Hull Civic Society
Promoting the Future - Protecting the Past

Mr. S Mounce
Planning Department
Hull City Council
Guildhall
KINGSTON UPON HULL
HU1 2AA

Ref. No: 19/00333/FULL Application for full planning permission for the demolition and partial rebuilding of the Earl de Grey public house; erection of link extension to Castle Buildings and the Earl de Grey; external alterations to Castle Buildings; use of relocated Earl de Grey, Castle Buildings and link extension for café or restaurant (A3) and/or drinking establishment (A4) and/or office (B1a); the erection of a nine-storey hotel; new public realm and associated works, including landscaping, car parking and servicing, and associated infrastructure.

Ref. No: 19/00334/LBC Application for listed building consent for demolition and partial rebuilding of Earl de Grey Public House; erection of link extension to Castle Buildings and Earl de Grey; refurbishment, reconfiguration of, and external alterations to Castle Buildings.

By Department Legend

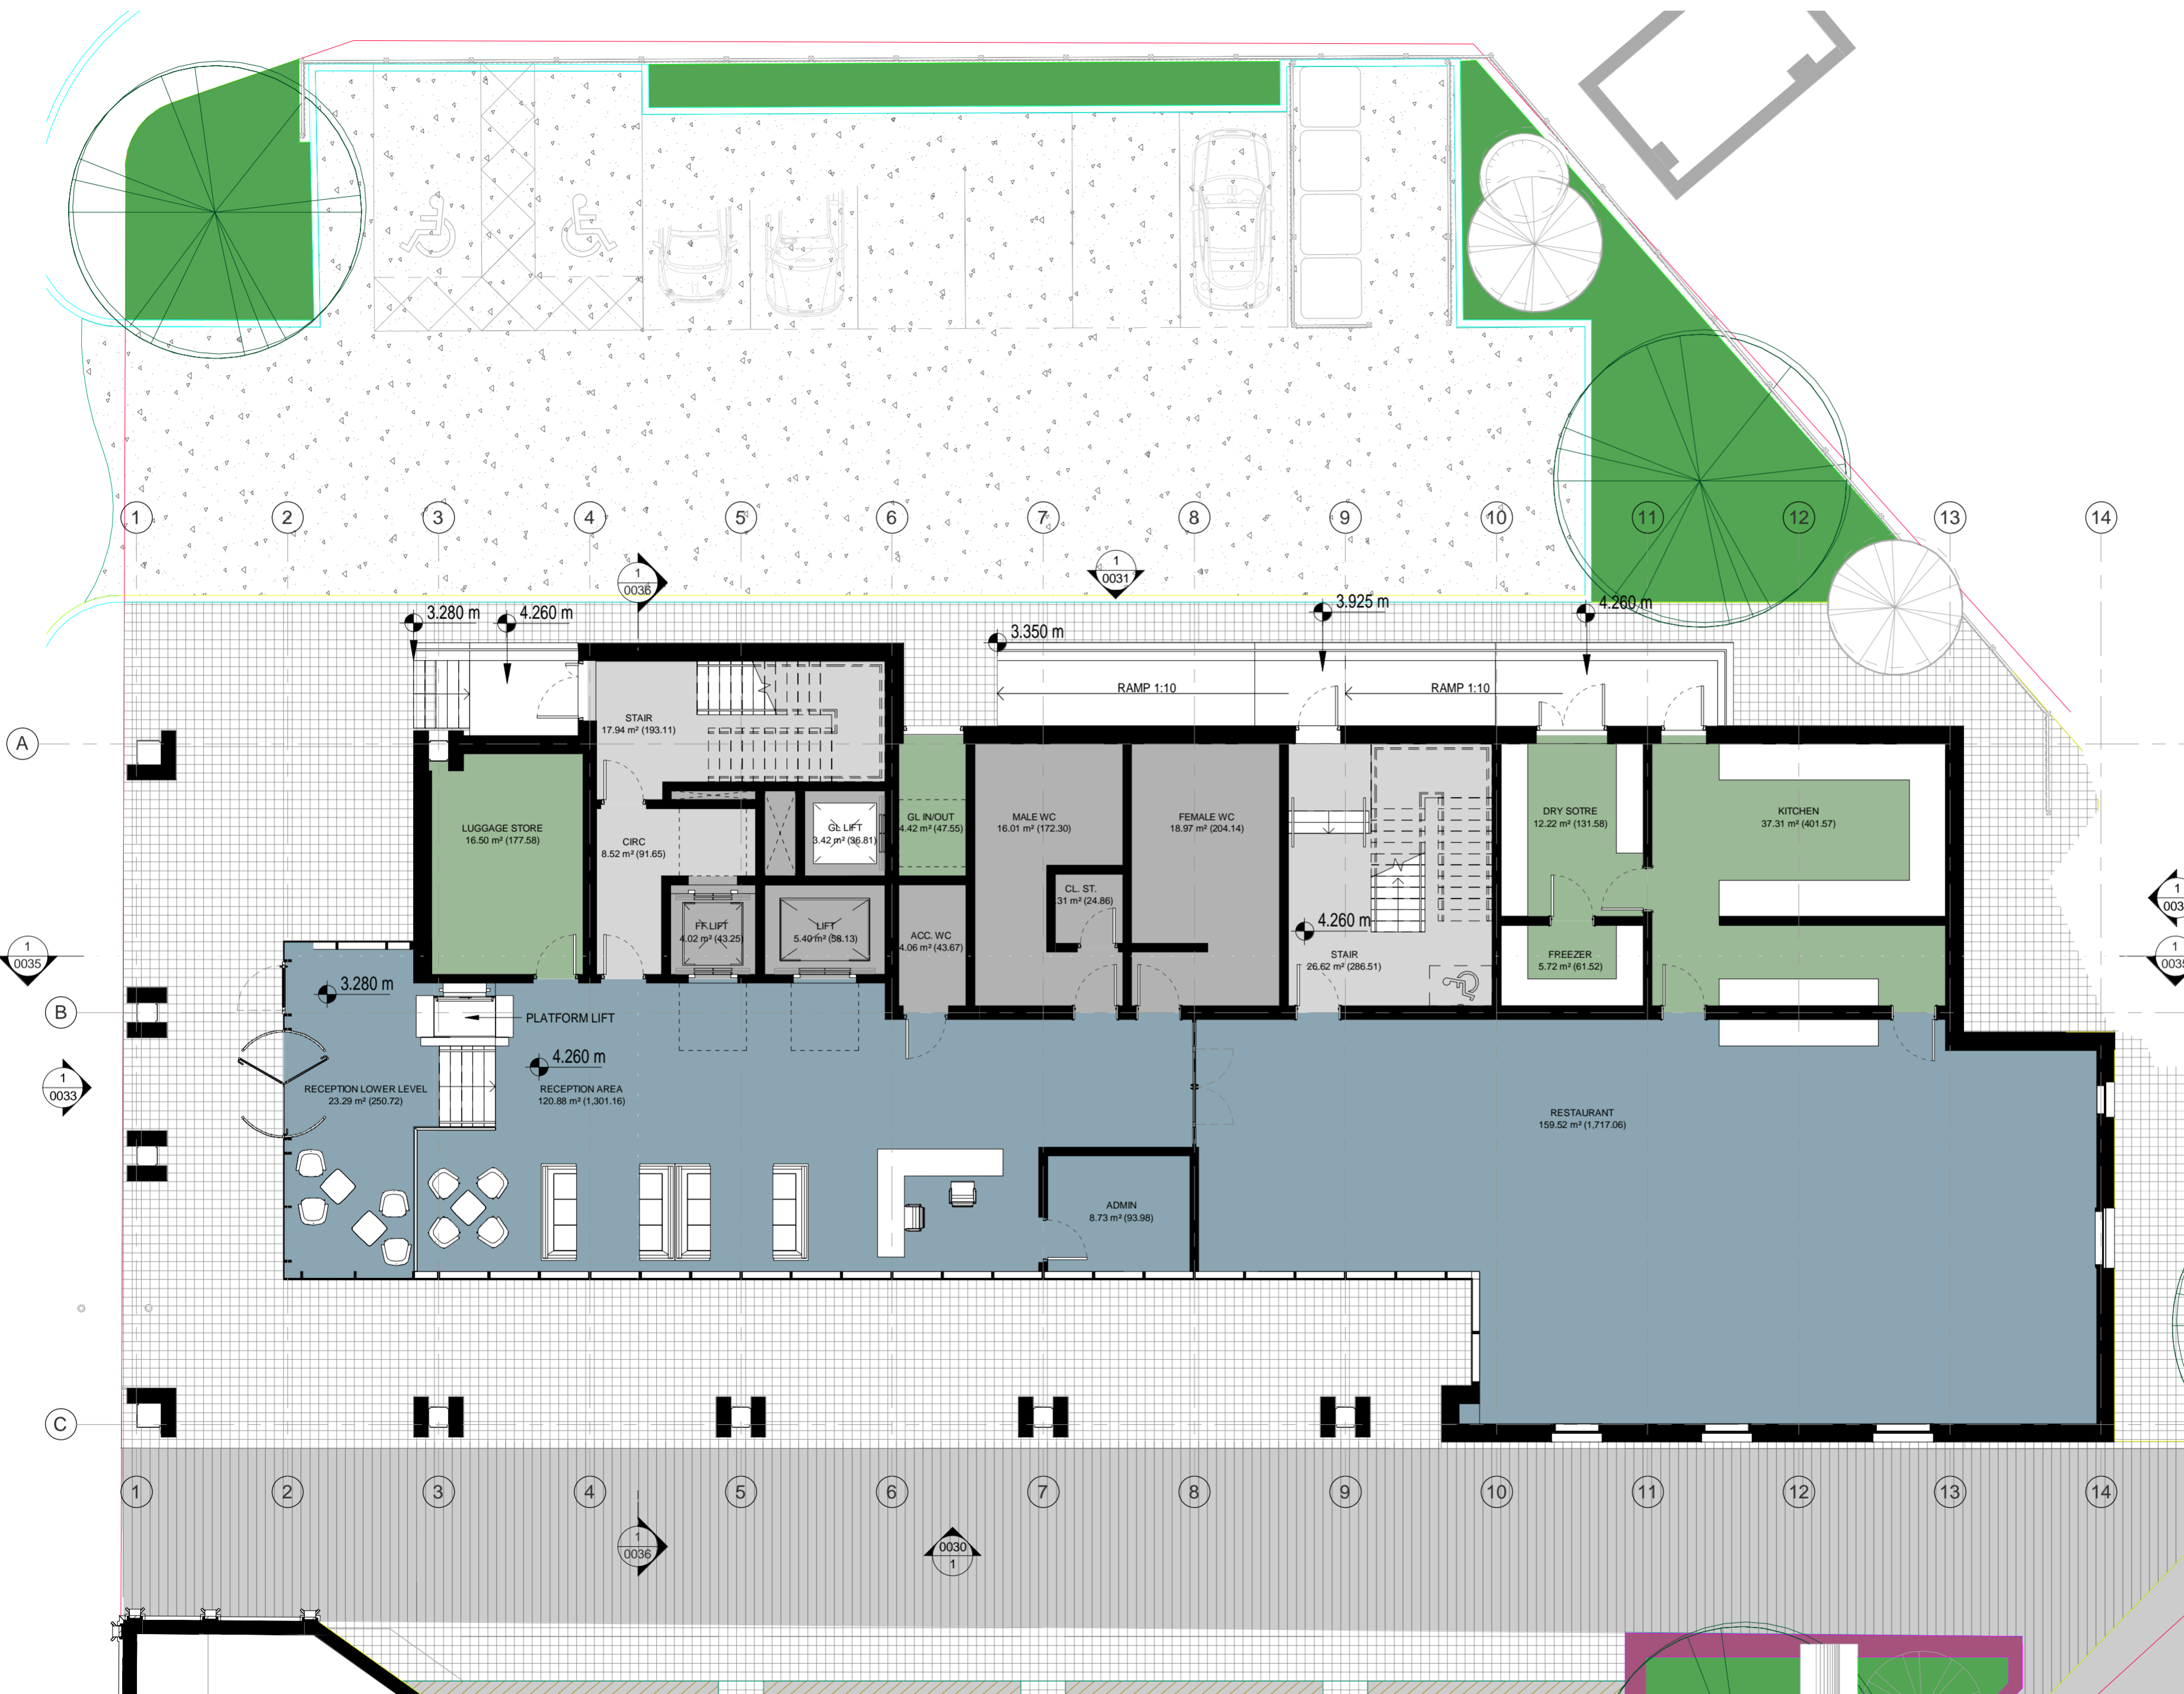
We are also concerned that the ground floor plans do not appear to recreate the layout appropriate to a working pub, with bar and back-bar. This, we consider essential to retaining the character of this listed building. The location of the staircase needs to be amended to allow more room for the pub to function as such.
